From: Mark Peacock
Sent: 17 November 2016 10:25
To: Planning
Subject: FW: Planning application 6/2016/0616/FULL - 2 De Havilland Close

From: Anthony Collier [mailto:Anthony.Collier@hertfordshire.gov.uk]
Sent: 17 November 2016 09:43
To: Mark Peacock
Subject: RE: Planning application 6/2016/0616/FULL - 2 De Havilland Close

# EXISTING AND PROPOSED SITE AND PARKING LAYOUTS

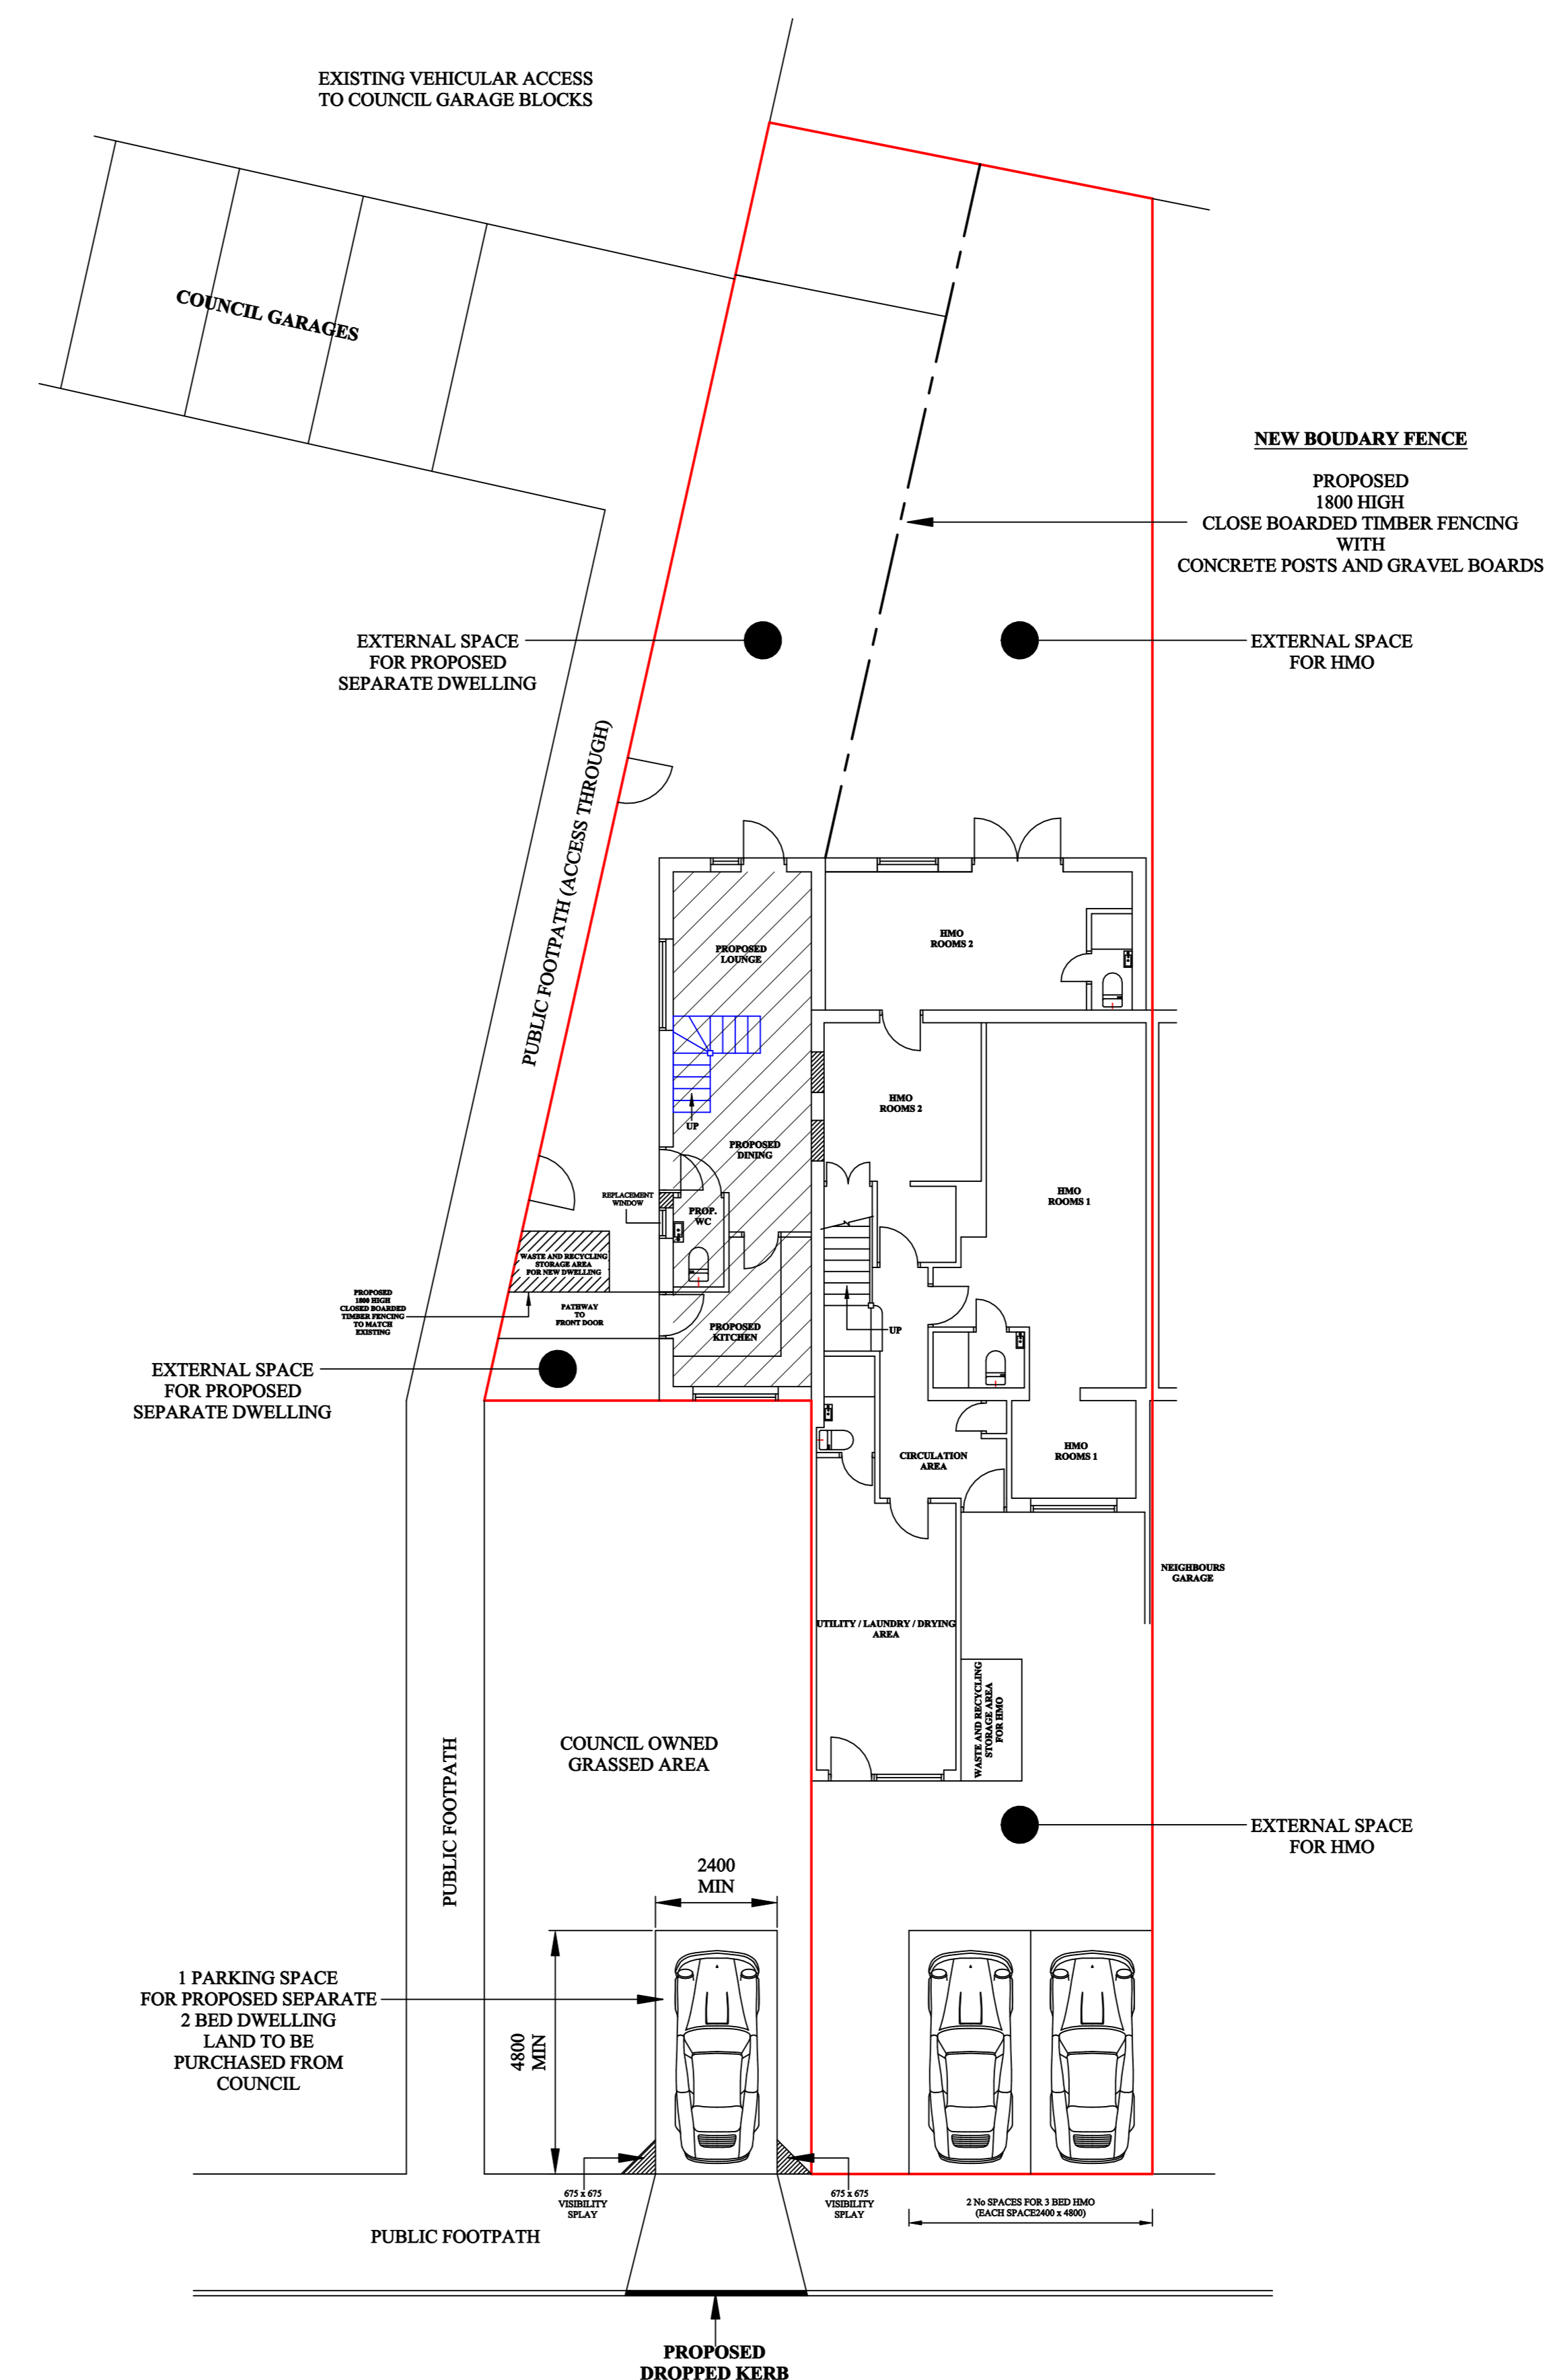
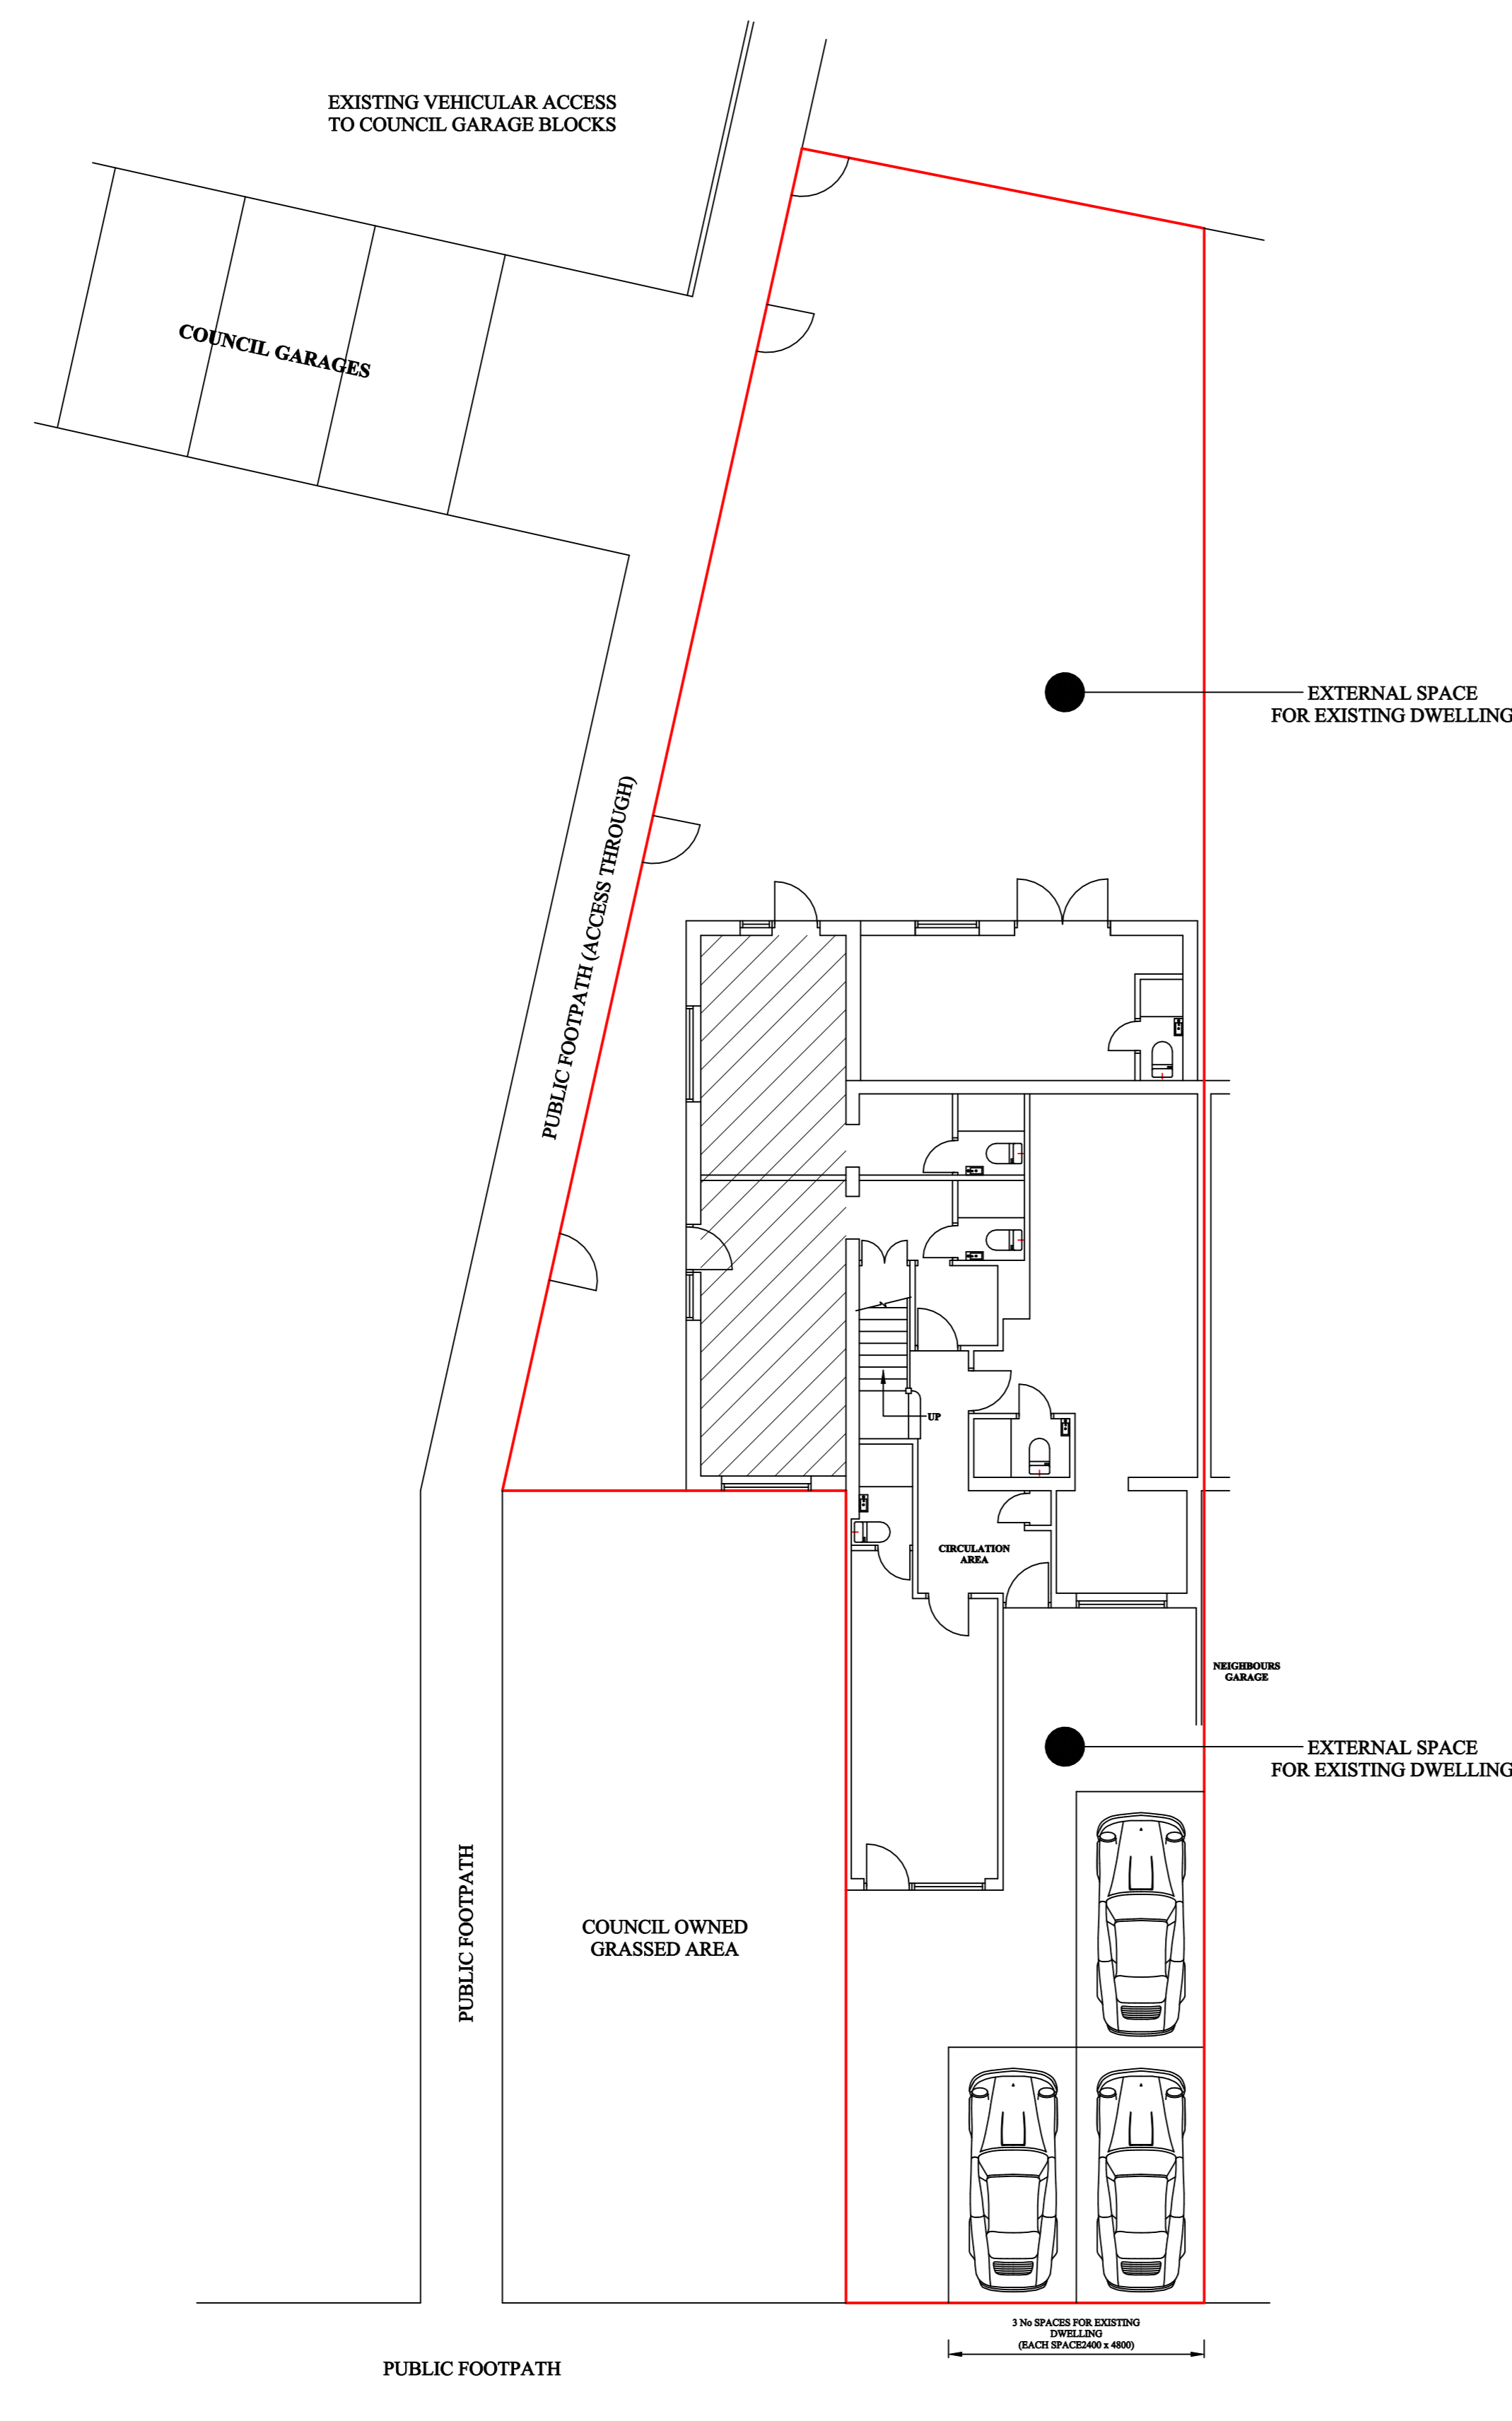
Hi mark, Ive looked at the site, it would be acceptable

The application site is for the Conversion of dwelling house into 2no dwelling houses located within the existing residential area De Havilland Close in Hatfield. It is noted that in the planning application form whilst the extension is for one dwelling into two, the current dwelling is laid out as a four bedsit welling, and will remain so in the proposal. The proposed site access to the front of the property would be acceptable in highways terms. Visibility is sufficient and distance from junctions acceptable in highways terms.

New or amended crossover – construction standards AN4) Construction standards for new/amended vehicle access: Where works are required within the public highway to facilitate the new or amended vehicular access, the Highway Authority require the construction of such works to be undertaken to their satisfaction and specification, and by a contractor who is authorised to work in the public highway. If any of the works associated with the construction of the access affects or requires the removal and/or the relocation of any equipment, apparatus or structures (e.g. street name plates, bus stop signs or shelters, statutory authority equipment etc.) the applicant will be required to bear the cost of such removal or alteration. Before works commence the applicant will need to apply to the Highway Authority to obtain their permission and requirements. Further information is available via the website <http://www.hertsdirect.org/services/transtreets/highways/> or by telephoning 0300 1234047
